REQUEST

Current Zoning: MUDD-O/I-2 (mixed-use development, optional & industrial)
Proposed Zoning: MUDD-O and MUDD-O SPA (mixed-use development, optional and mixed-use development, optional, site plan amendment)

Approximately 0.7 acres located SW of the intersection of Belmont Avenue and Seigle Avenue in the Belmont neighborhood.

The petition proposes a rezoning/site plan amendment that would allow for an existing building to be repurposed and permit up to 15,000 SF (10,500 SF in addition to existing building footprint) of limited non-residential uses permitted within the MUDD district.

### REZONING PETITION #2020-178

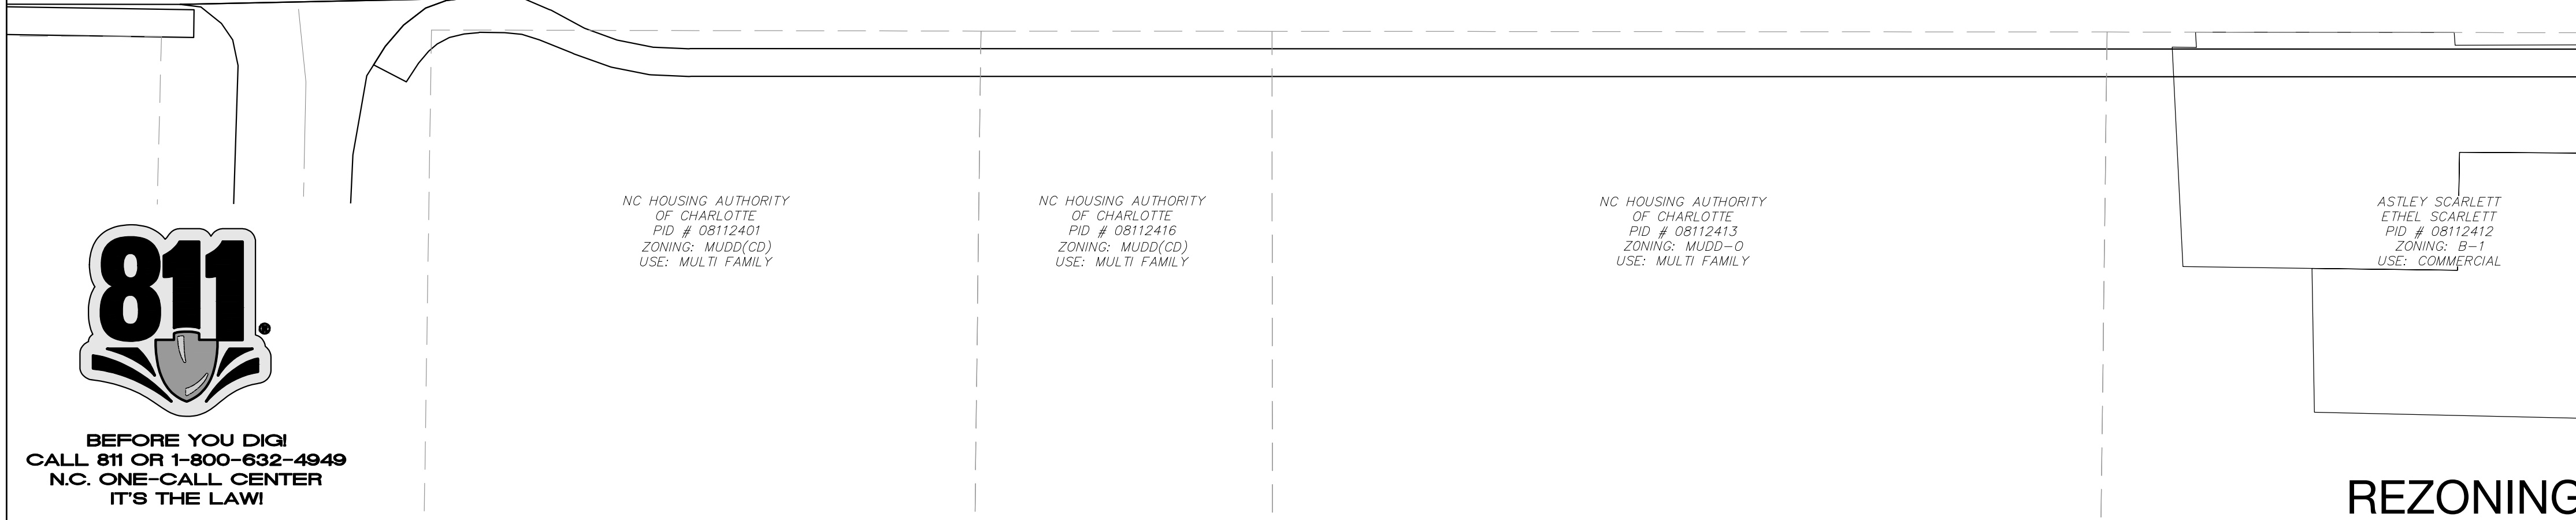
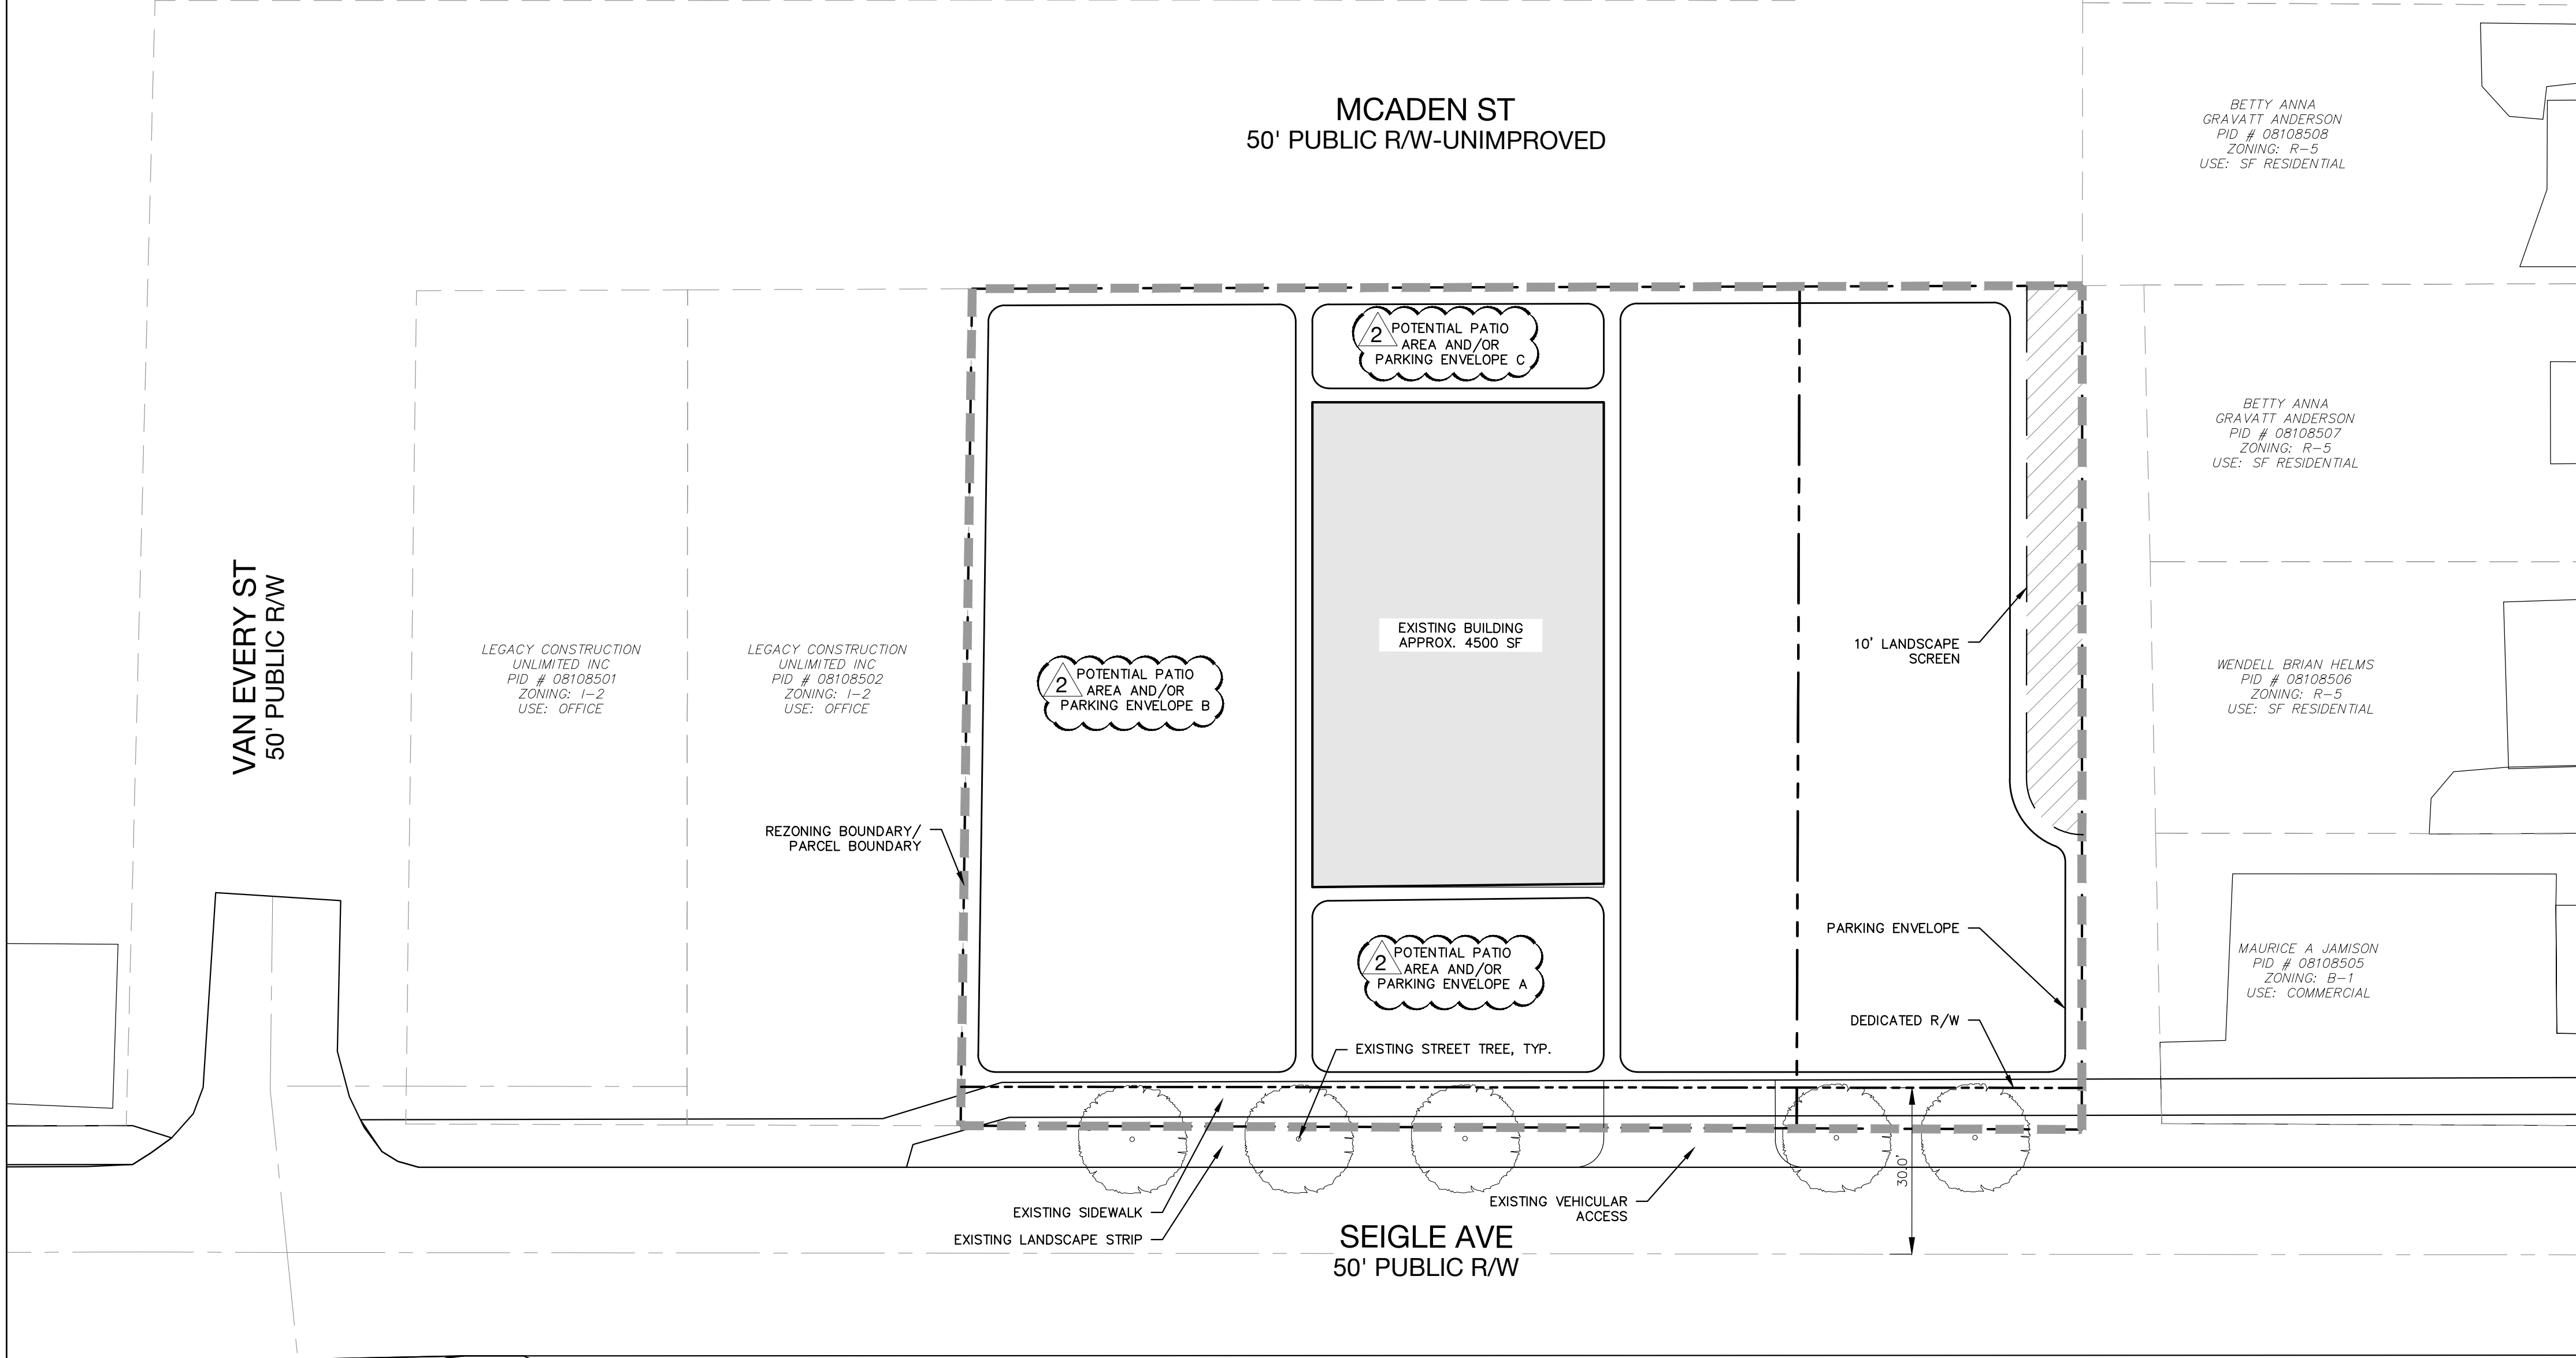
- ~~8. Adjust site development table to reflect parking required per ordinance and proposed building area up to 15,000 SF. **ADDRESSED**~~
- ~~9. Please clarify/reword notes 3 & 4 in optional provisions to more clearly reflect the provisions being asked for patio/parking areas. This revision should also note or cross-reference the above outstanding issue 7 regarding the location of parking in front of any future improvements/additions. **ADDRESSED**~~
10. As parking is not permitted within potential patio area and/or parking envelope A, please remove reference to parking in that area. **OUTSTANDING**
